Application by Highways England for an Order Granting Development Consent for A57 Link Roads

Deadline 9 - response on behalf of High Peak Borough Council

**6.4 Environmental Statement  
Figure 5.2(i) Air Quality Model Sensitive Receptors**

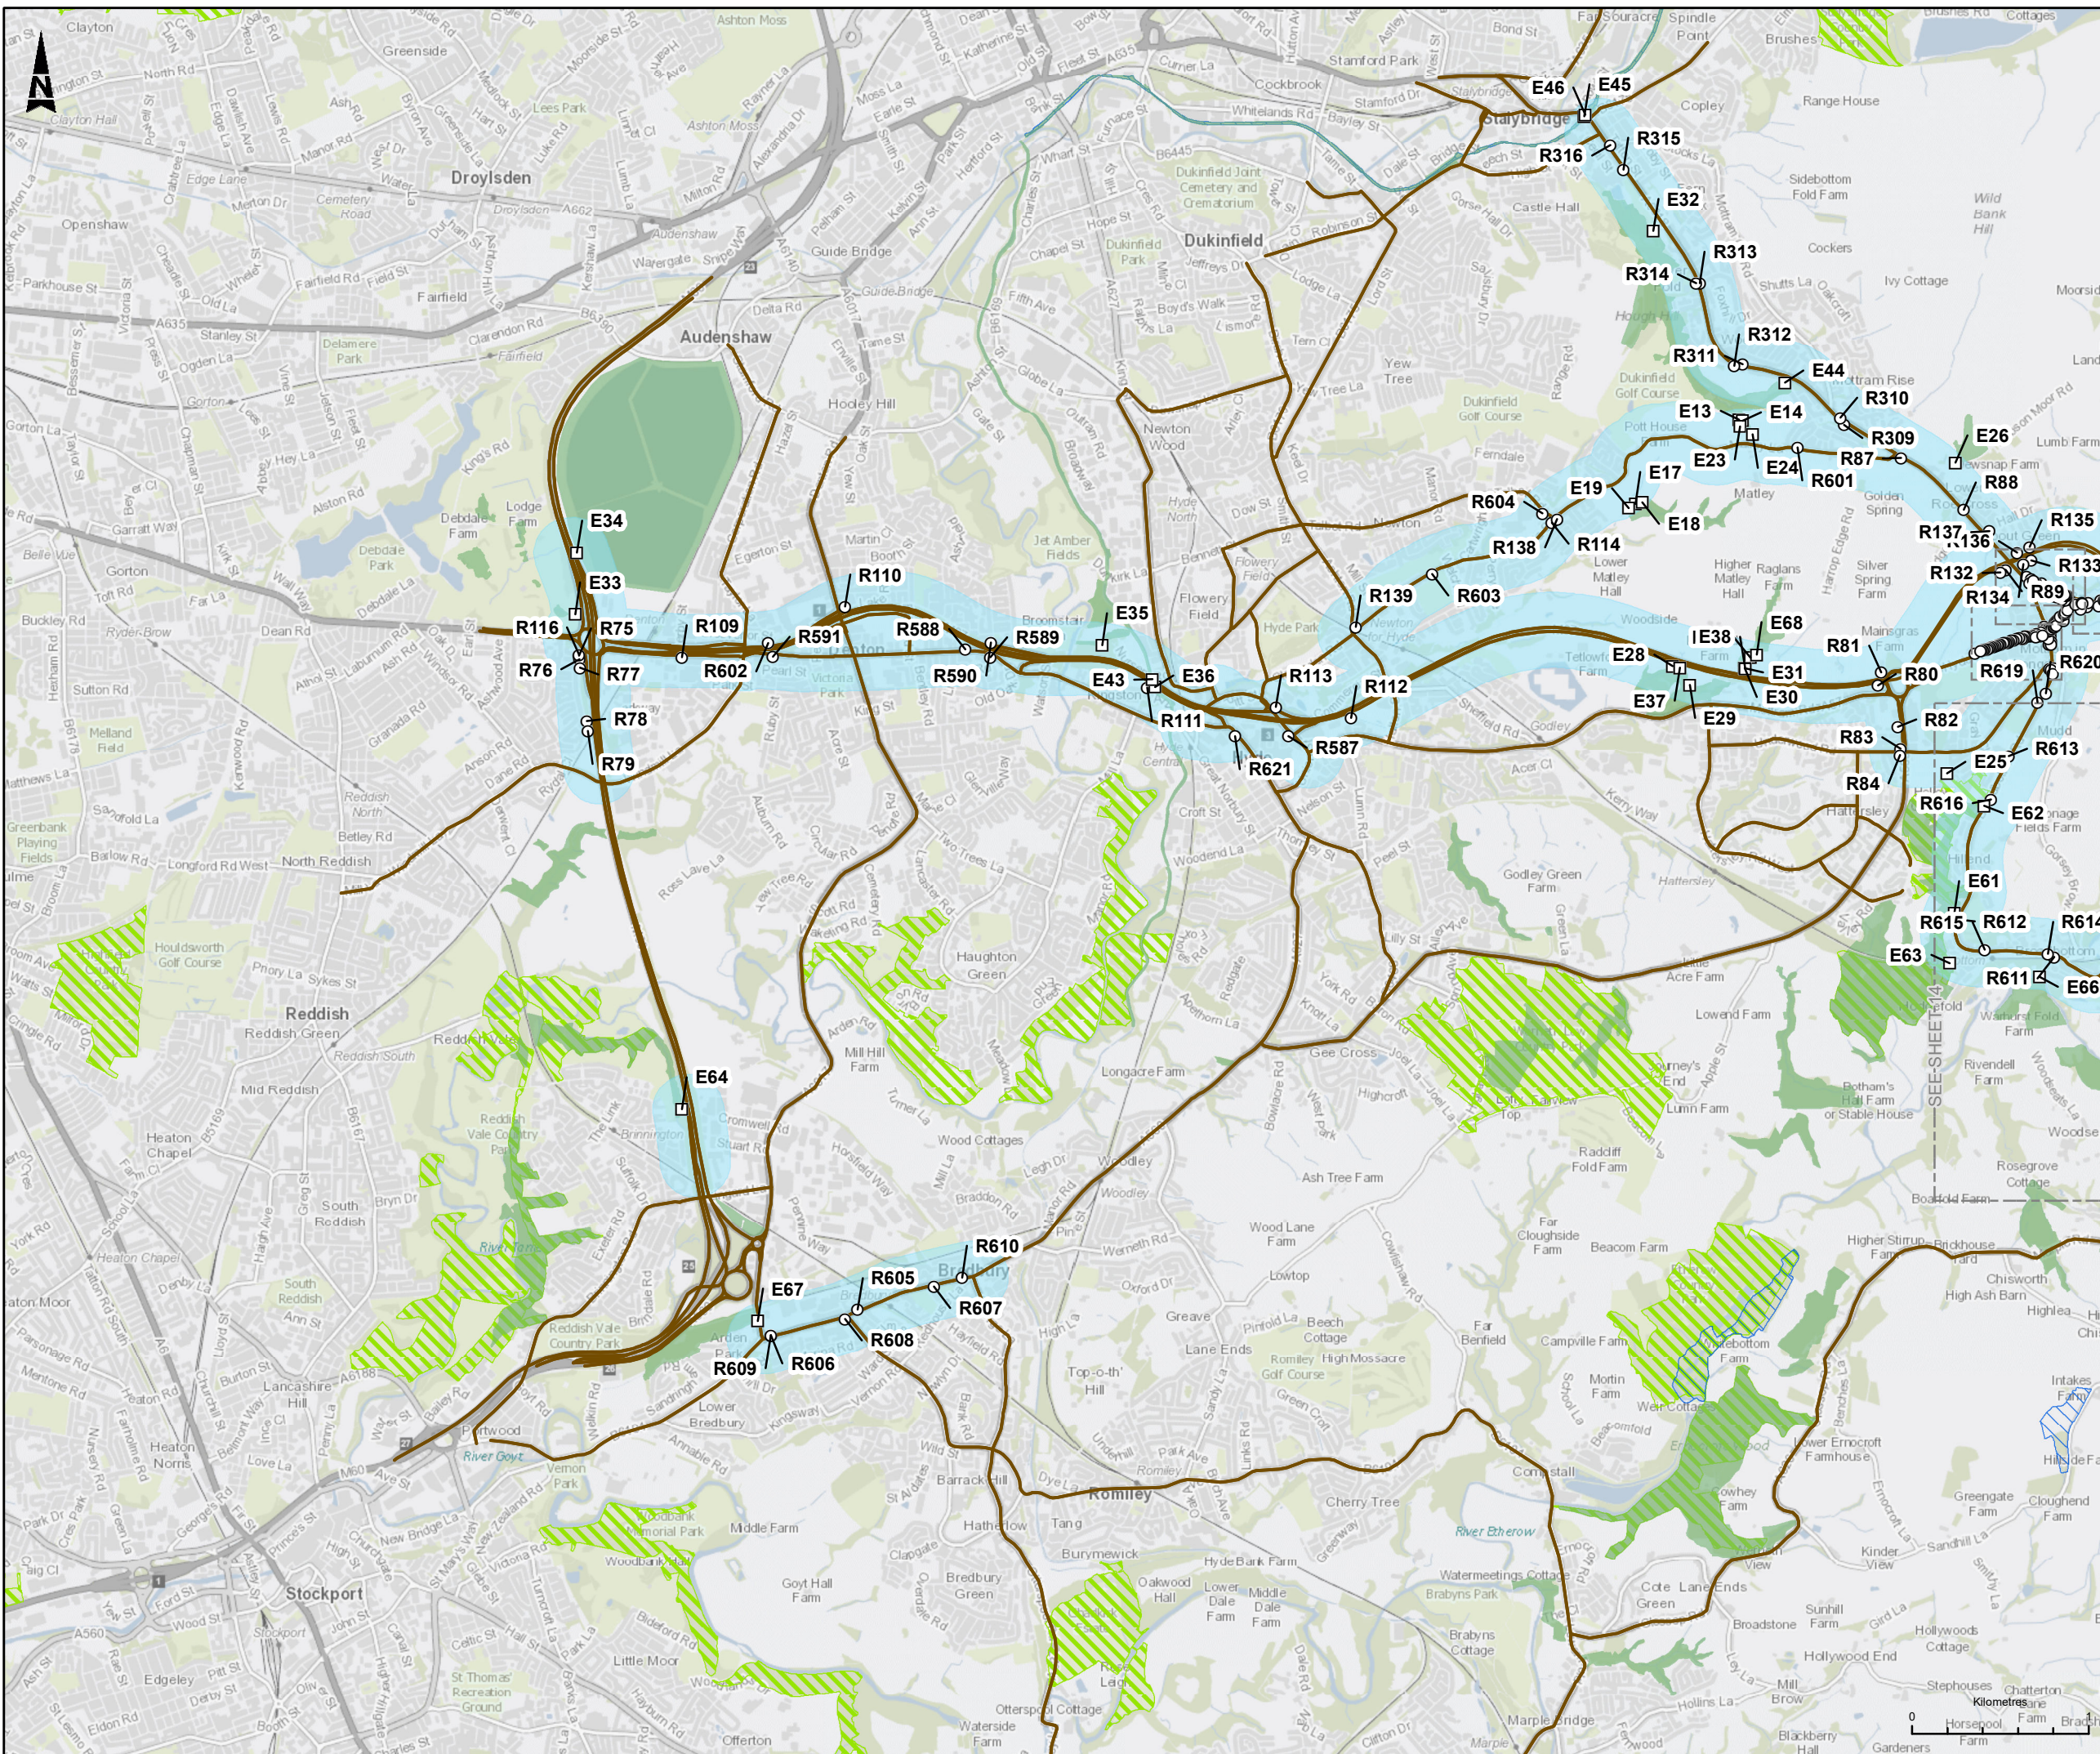
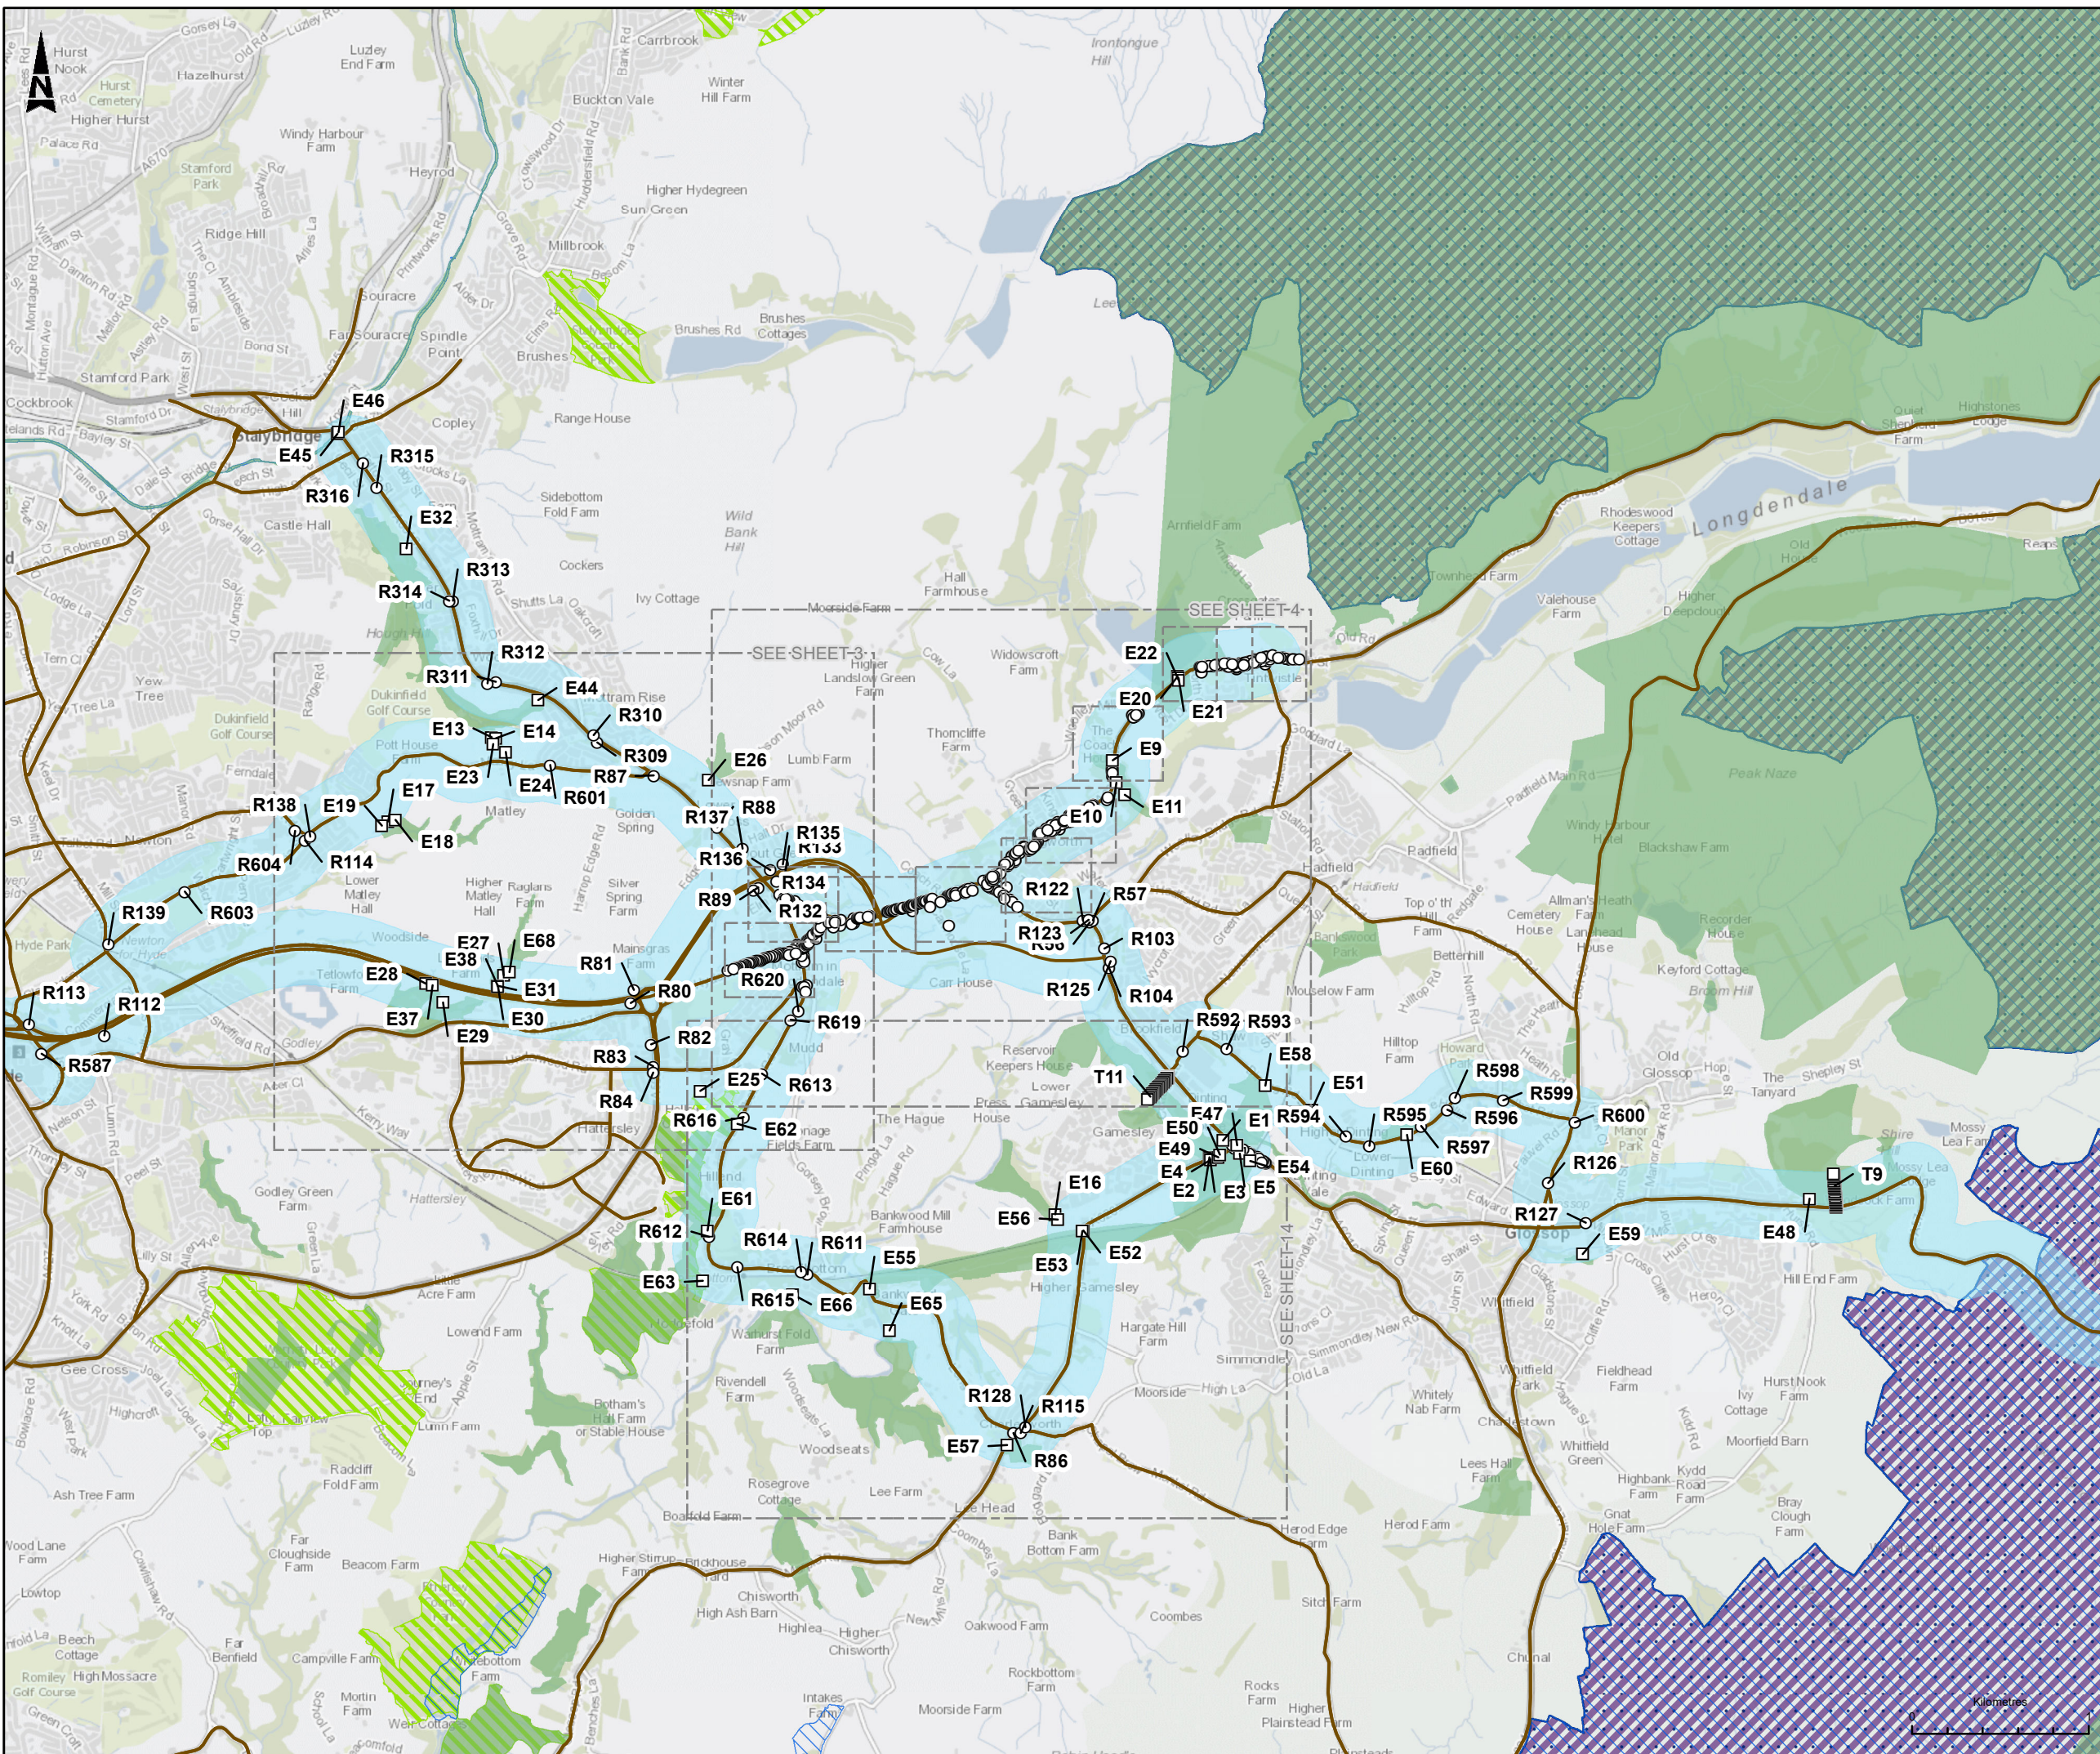
- *“The outcomes of the air quality assessment indicate there would be significant improvement in terms of annual mean NO2 concentrations at sensitive, human health receptors within the air quality study area. The Scheme will deliver improved air quality for all but one local receptor.”*

At the time of writing, the applicant has failed to properly assess the impacts of the scheme on the Air Quality Management Areas at Dinting and Tintwistle. As such, claims regarding significant improvements to air quality at sensitive human health receptors cannot be verified.
